Appendix 1C: Cappamore-Kilmallock Municipal District Council (MDC) 16th January 2020

Table C.1: Cappamore-Kilmallock Municipal District Council (MDC) 16th January 2020

Cappamore-Kilmallock Municipal District Council (MDC) Meeting 16th January 2020	
 positive" reaction to the proposals but that clarifications were being sought including: Width of the proposed carriageway; Measures to address unauthorised parking and dumping; Possible provision of a footpath on the overbridge; and Any weight restrictions. 	 existing road widths would cause safety issues at the tie-in points, where drivers may have increased their speeds due to the wider carriageway, and then would have to suddenly revert back to the existing 4m wide road cross section. It was agreed that Jacobs would look into possible 'future proofing' of the structure, where the overall road carriageway would tie-in with existing, but the structure would be built to allow for future widening of the carriageway if Limerick County Council were to improve the surrounding road network in the future; 2) The police and both councils have legal powers to prevent unauthorised parking and dumping; 3) No existing footpath in locality to ti

NTS FIGURE 2 XC187 - FANTSTOWN

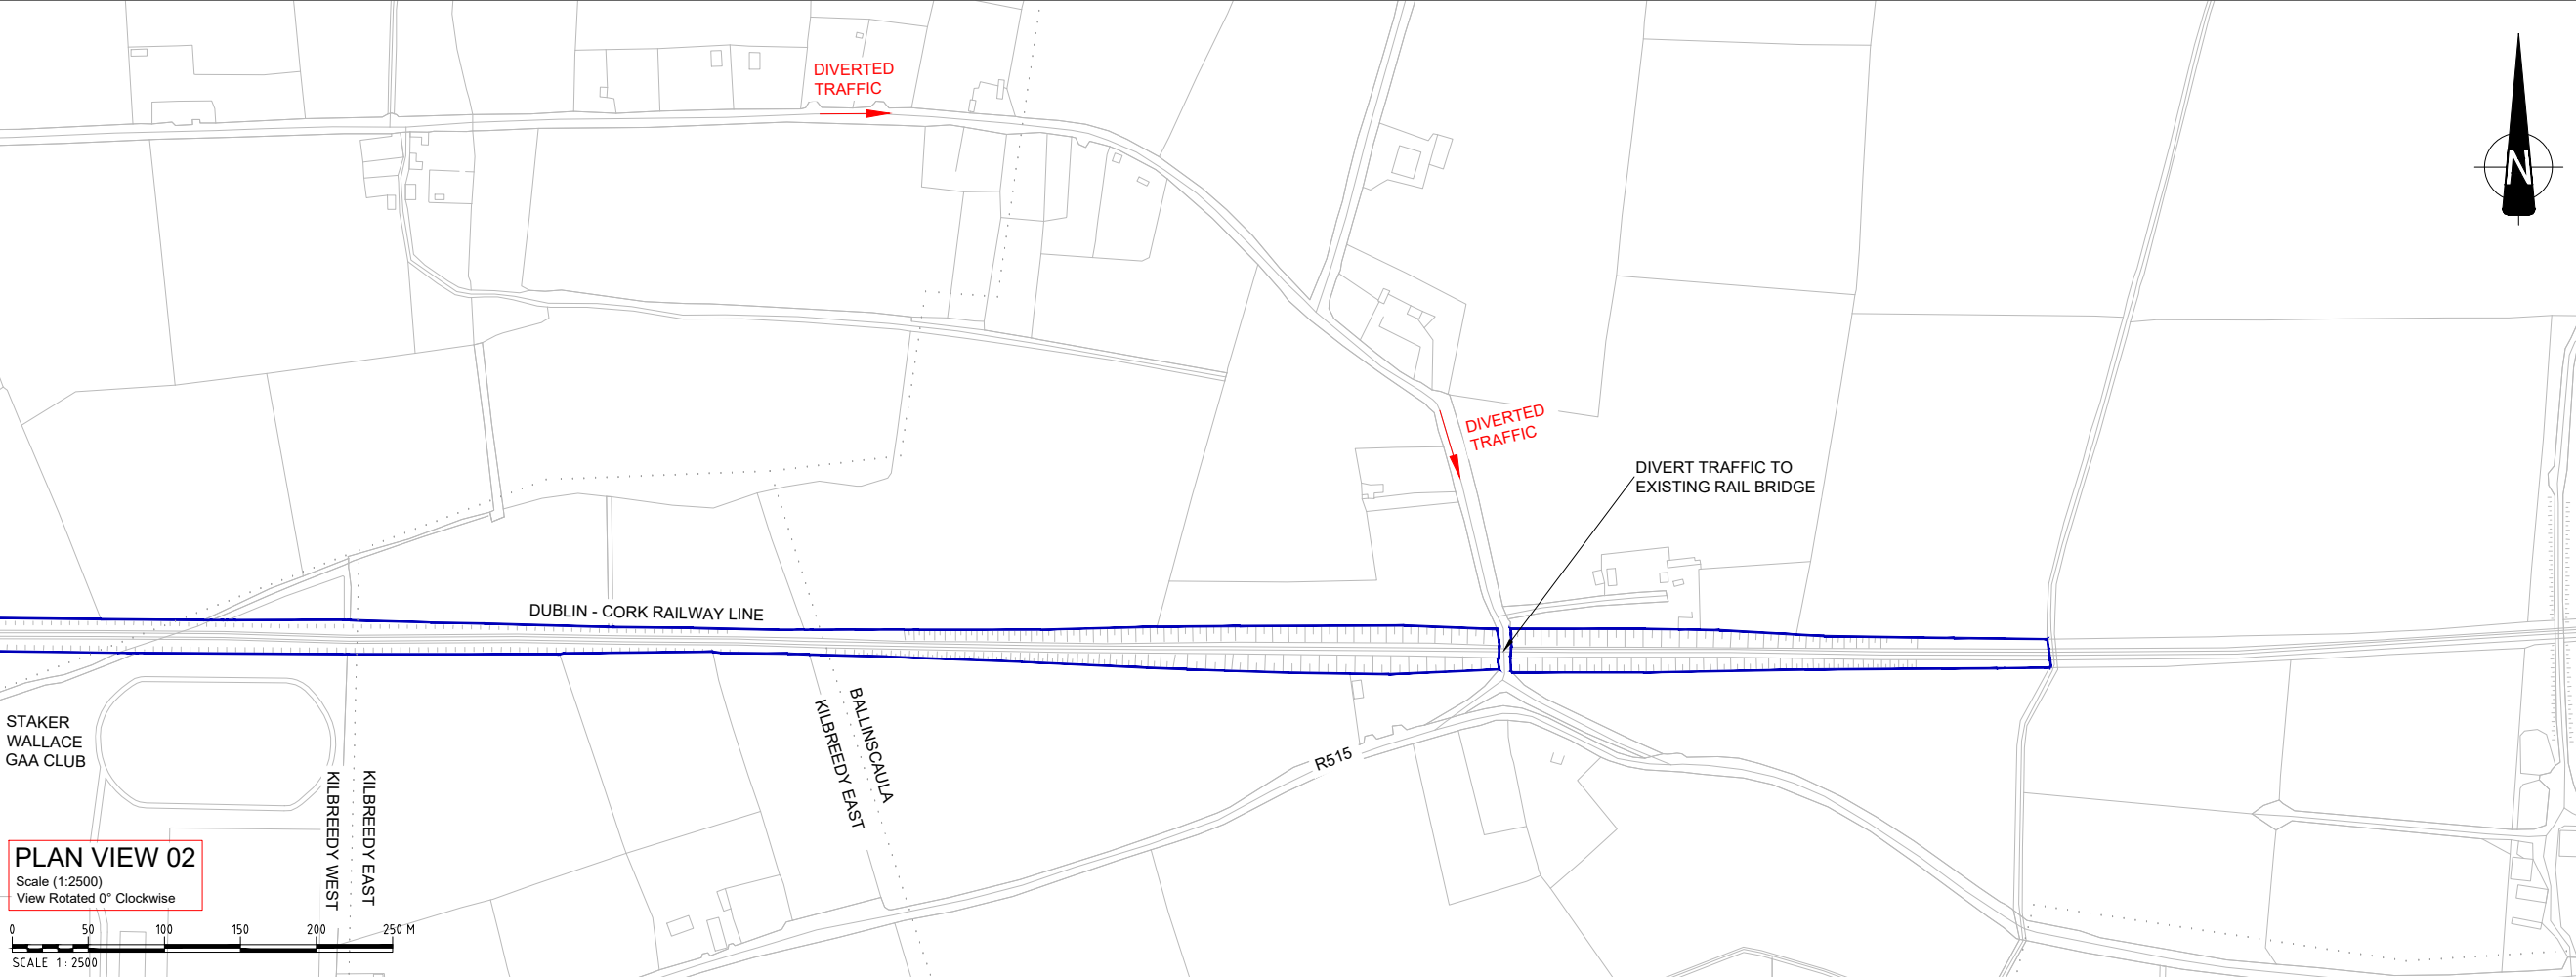
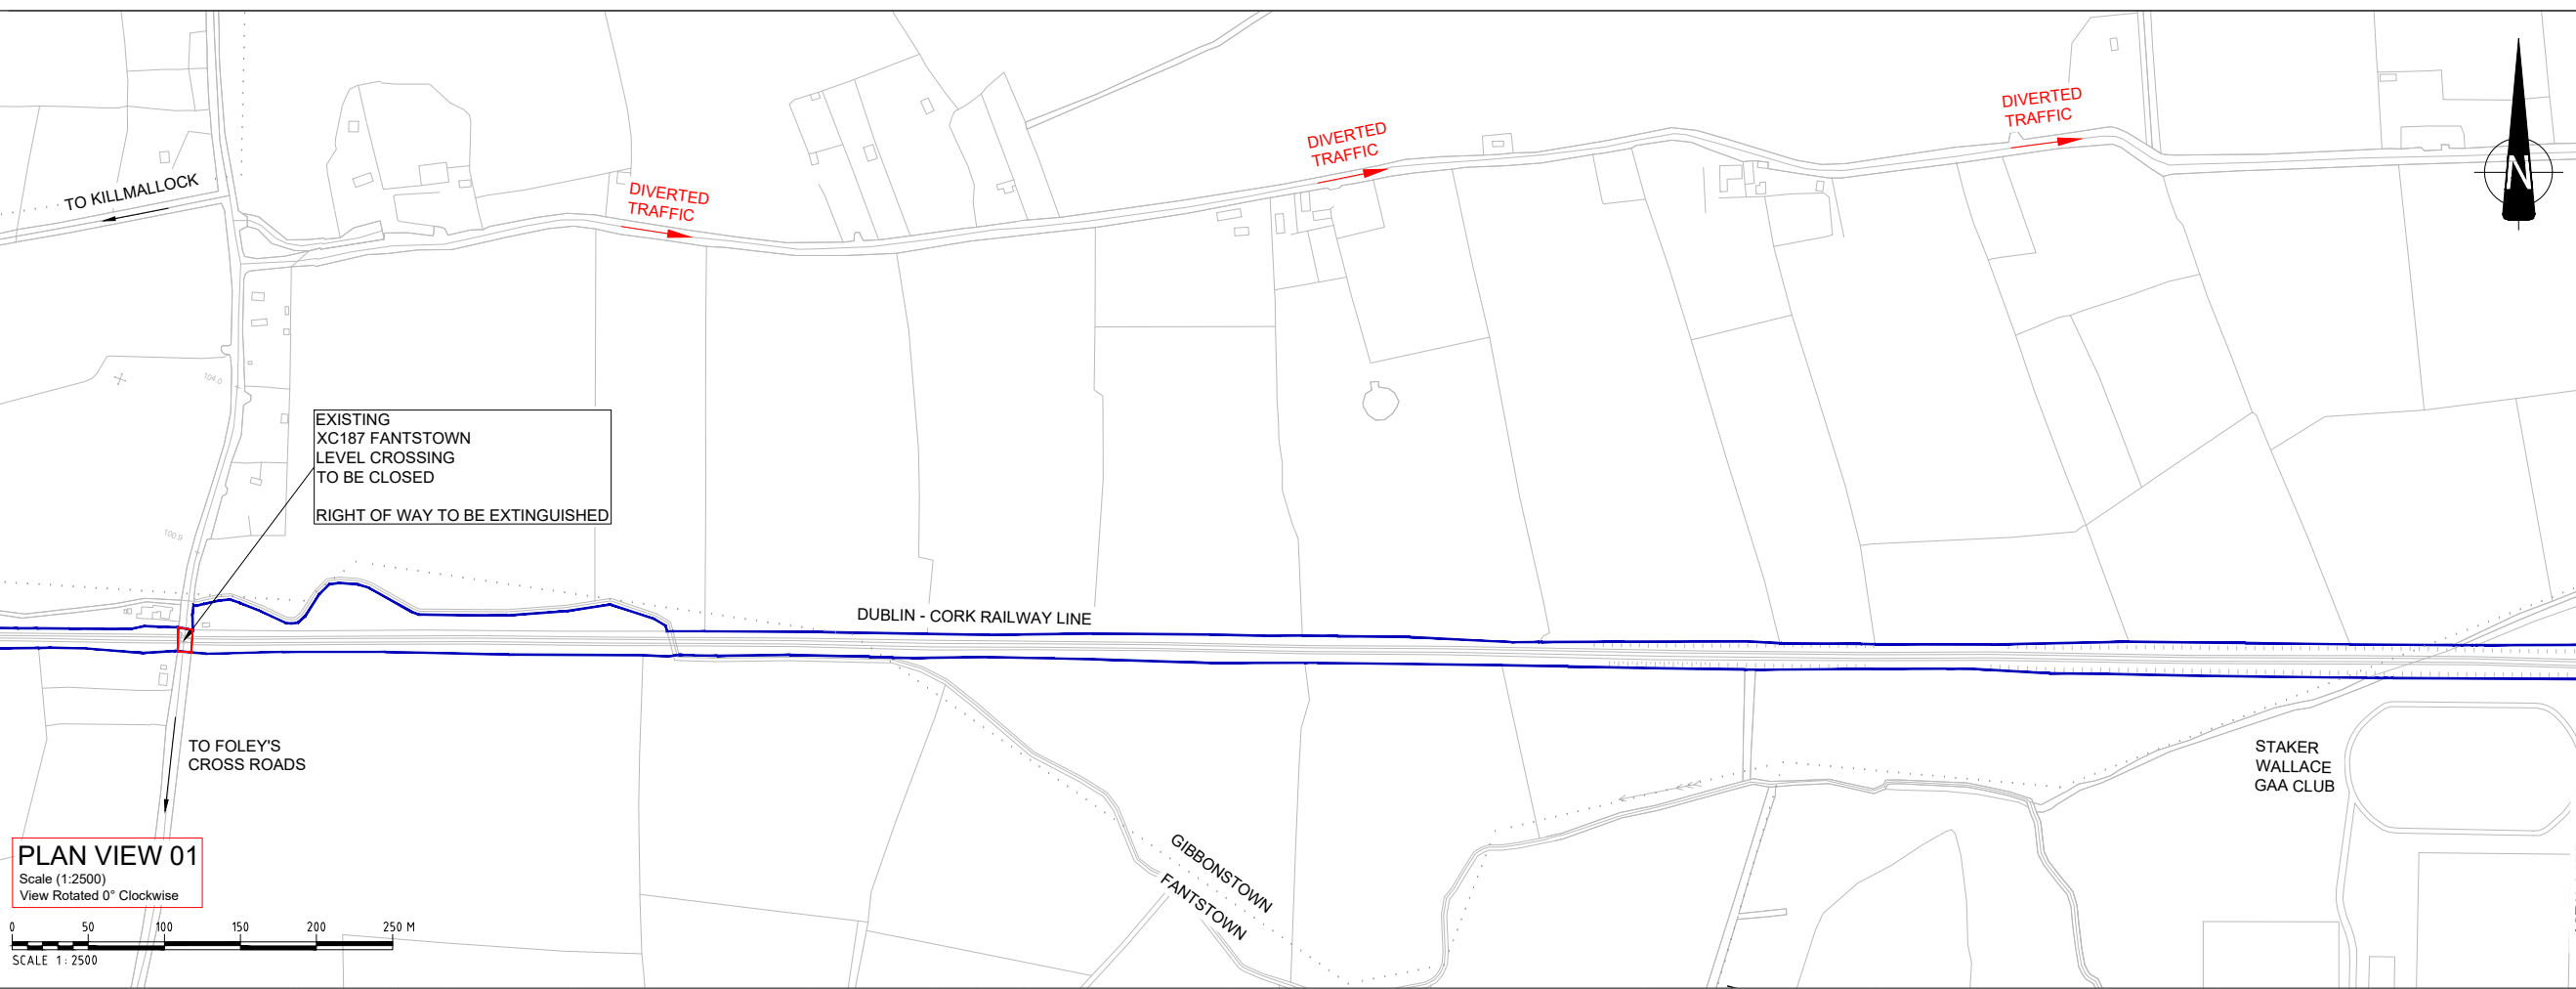
Issues Raised	Response/Where this is addressed
Issues Raised In regard to Fantstown, Elected Members outlined concerns raised by local community regarding the lengthy diversion involved and that the community was being split in two with the suggested closure of this railway crossing. Unanimously requested consideration of an overbridge.	Response/Where this is addressed Volume 2, Chapter 2: Project Need and Alternatives includes at Table 2.1 a comparison between the 2011 traffic surveys and those undertaken in October 2019. The surveys demonstrate a low volume of movements across the existing Fantstown level crossing. Furthermore, the 2009 Oral Hearing regarding an " <i>Extinguishment of Public</i> <i>Right of Way Over Part of Local Road LS8514</i> ", at Level Crossing XC187 at Fantstown, Kilmallock, Co. Limerick under Section 73 of the Roads Act 1993 is still relevant as the level of usage at the XC187 Fantstown level crossing has remained consistently low. The Inspector in his recommendation found "from my own inspections of the <i>location and given the current restrictions on and the very low level of usage of Fantstown level crossing, I believe the</i> <i>substantial public safety arguments in favour of the</i> <i>proposed Extinguishment outweigh those made against.</i> " On the basis of the consistently low volume of usage, the results of the Feasibility Assessment, the updated multi criteria analysis at Volume 2, Chapter 2; Project Need and Alternatives, the Project Team considered that an overbridge solution should not be taken forward. Volume 3, Chapter 6: Population and Human Health has undertaken an assessment on the severance that would be caused as a consequence of the proposed Project.

Project:	CORK LINE LEVEL CROSSINGS		
Component:	RAILWAY ORDER SCHEDULE DRAWING		
Title:	PROPOSED SITE PLAN - XC201 THOMASTOWN - SHEET 2 OF 2		
Designed:	SK	File Name:	-
Drawn:	JR	Original scales:	PLAN 1:500 @ A1
Checked:	FMD	Date:	DEC '20
Drawing No.:	32111000-JAC-LUH-XC201-DR-CH-0004(ii)

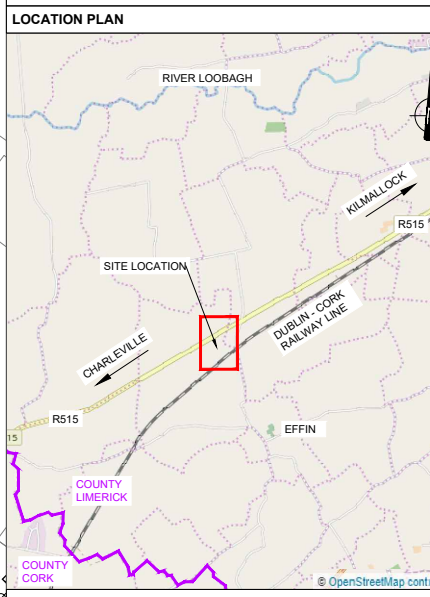
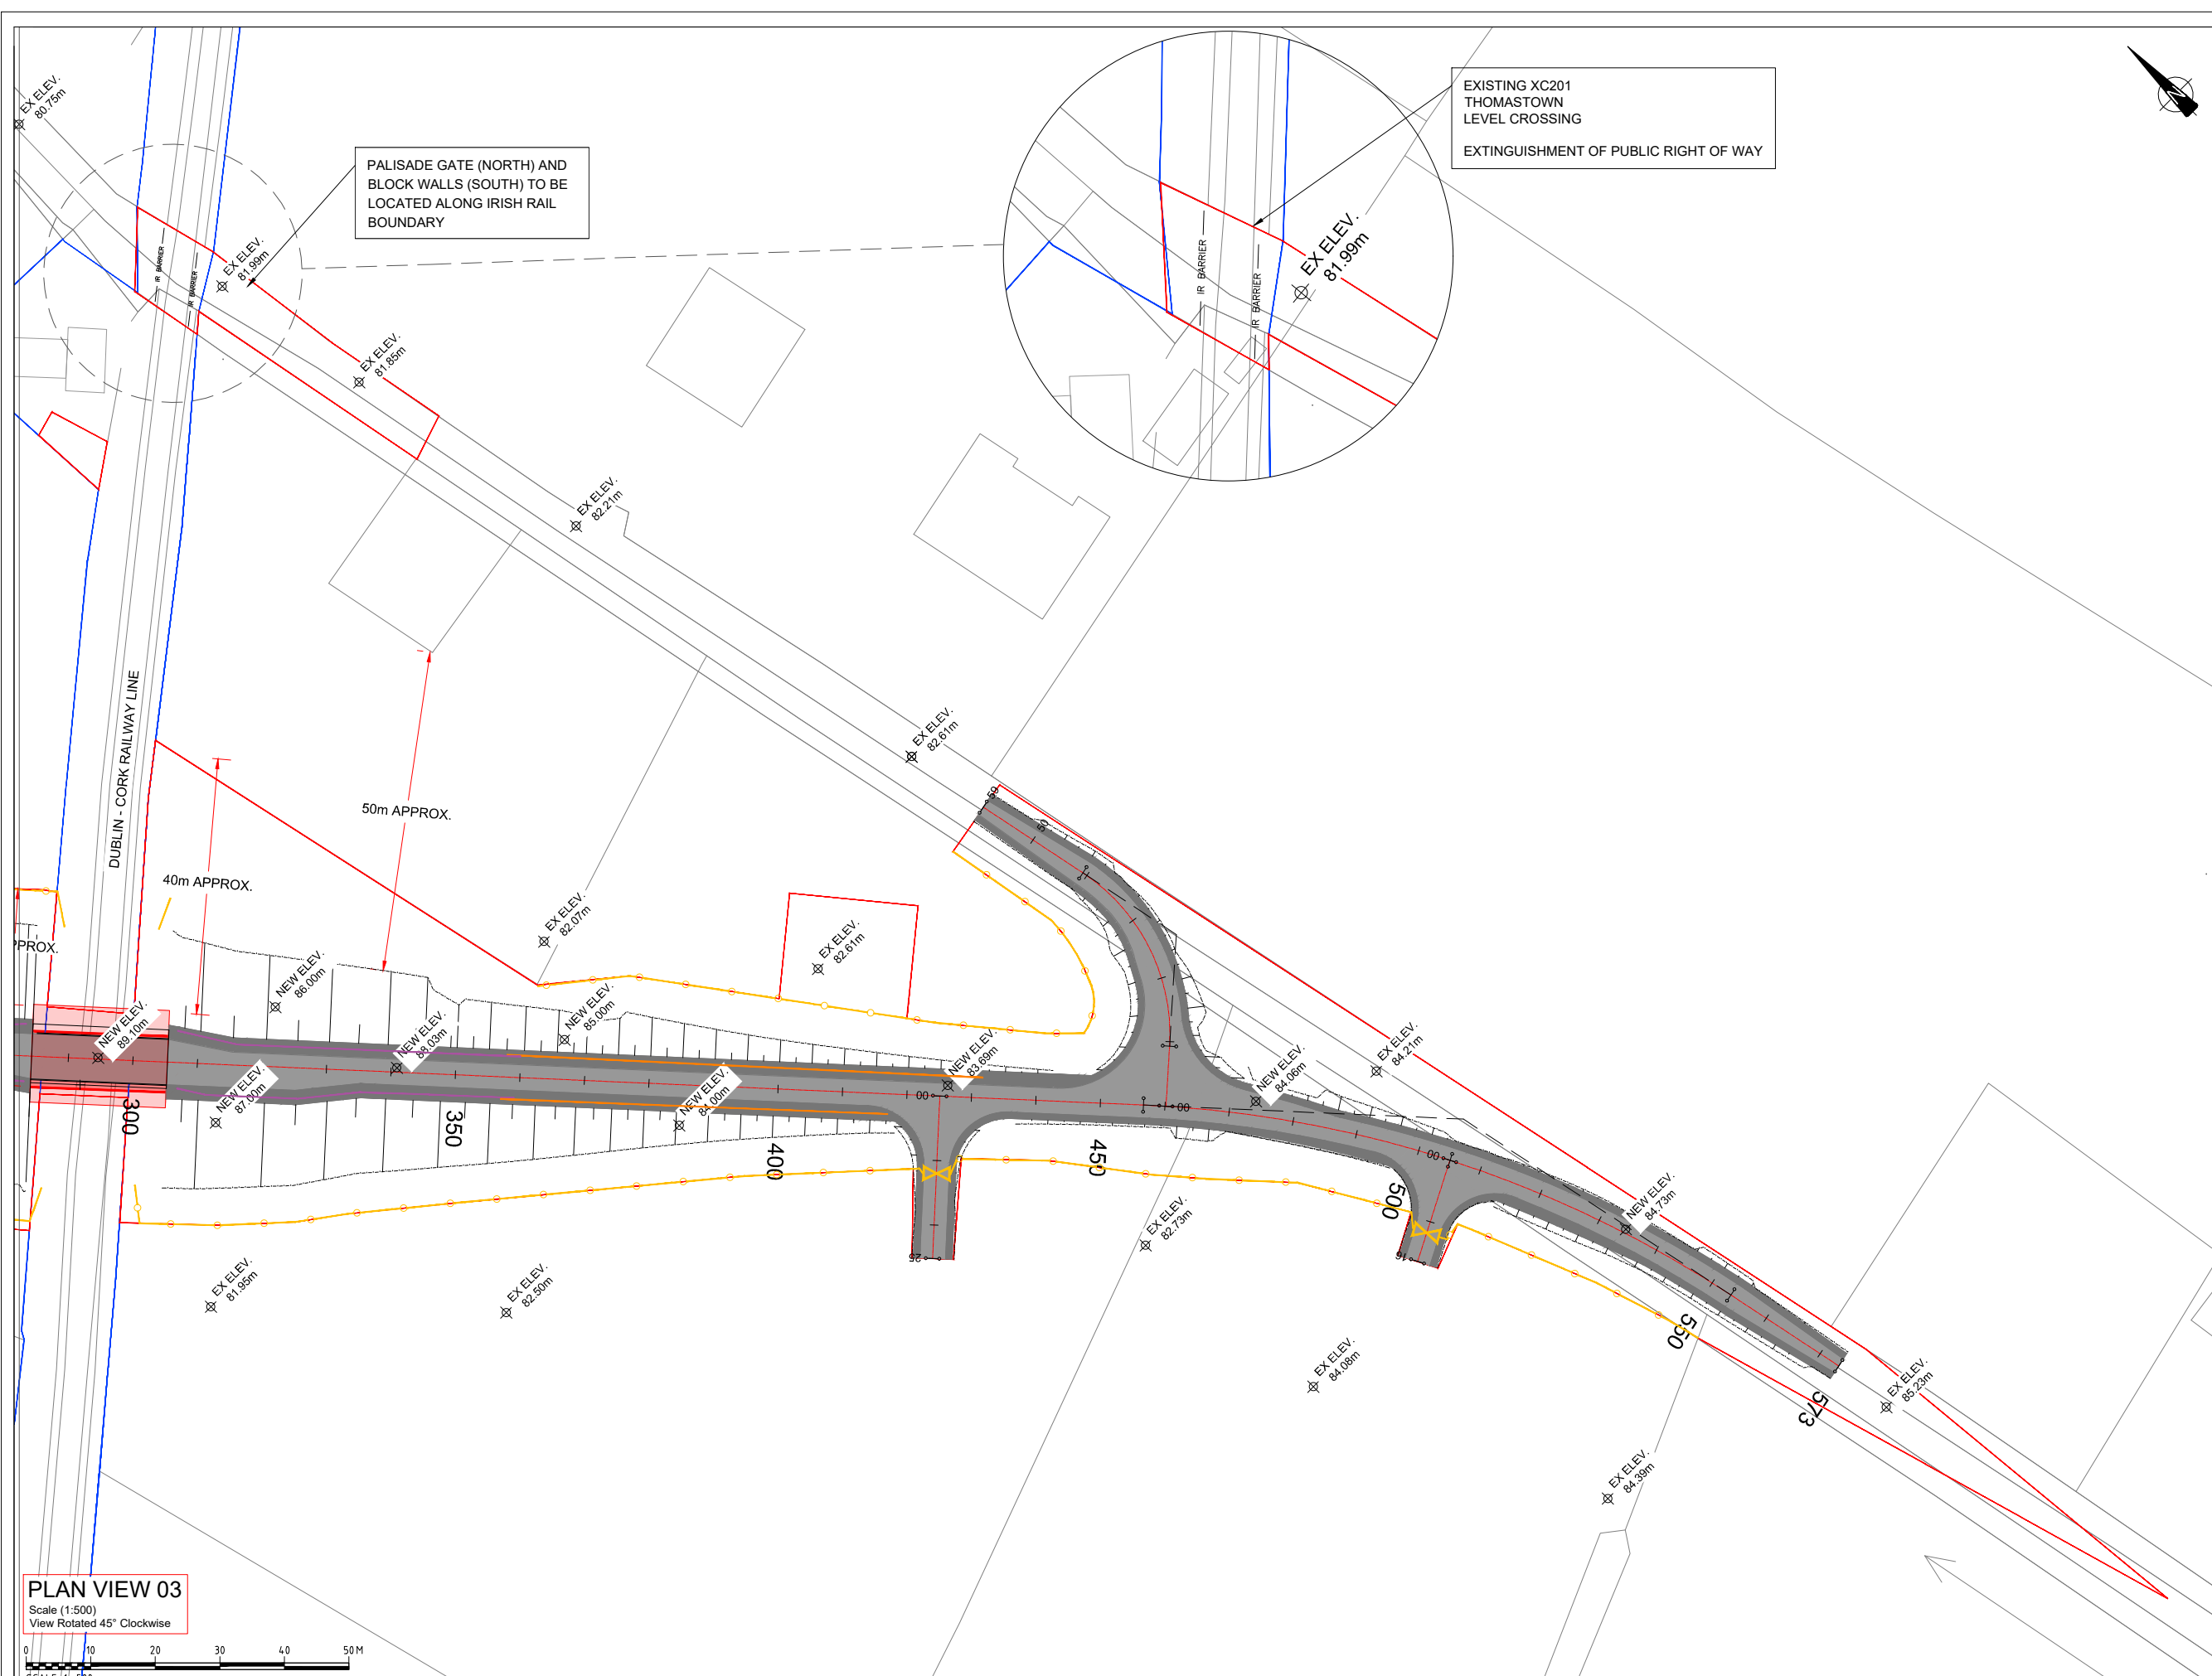
In regard to Thomastown reference was made to a recent community meeting. It was noted there was a <i>"reasonably</i>	 It was noted in the meeting by both Jacobs and Diarmuid Sheehy that widening this proposed short length of proposed carriageway to more than the
